Application number: 2024/92168	
What is the application for?:	Outline application for erection of residential development of 13 dwellings
Address of the site or building:	Land south of, Leak Hall Barn, off Leak Hall Lane, Denby Dale, Huddersfield, HD8 8QU
Postcode:

Type of comment: An objection	
Do you wish your comments to be published on the website anonymously?	<input checked="" type="checkbox"/> Yes
<p>SERVICES – Leak Hall Farm’s existing electricity supply and sewer pipes run across this land, as do those of High Barn. The sewer was installed when the houses on Leak Hall Lane were built in 1960s or 70s. This is a small pipe, not capable of being connected into for this many extra dwellings, and likely to be damaged during building. It may even run under some of the new houses, certainly the paved areas shown. This sewer would require lengthy diversion, with considerable difficulty and inconvenience. The electricity to Leak Hall Farm and High Barn comes across the field to the pole, then continues underground. Other neighbours supplies run via wires from the pole. This is represented as a phone line in the application – it is not.</p> <p>Our own water meter, and those of neigh

DRAWING TITLE
VEHICLE TRACKING AND VISIBILITY

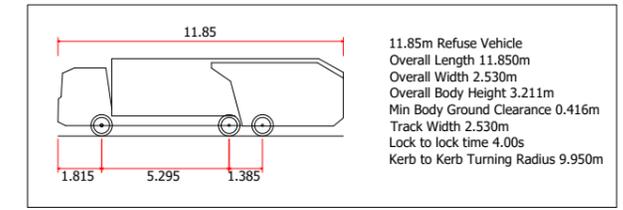
The new access & visibility splays disregard the difference in levels between the field and Leak Hall Lane.
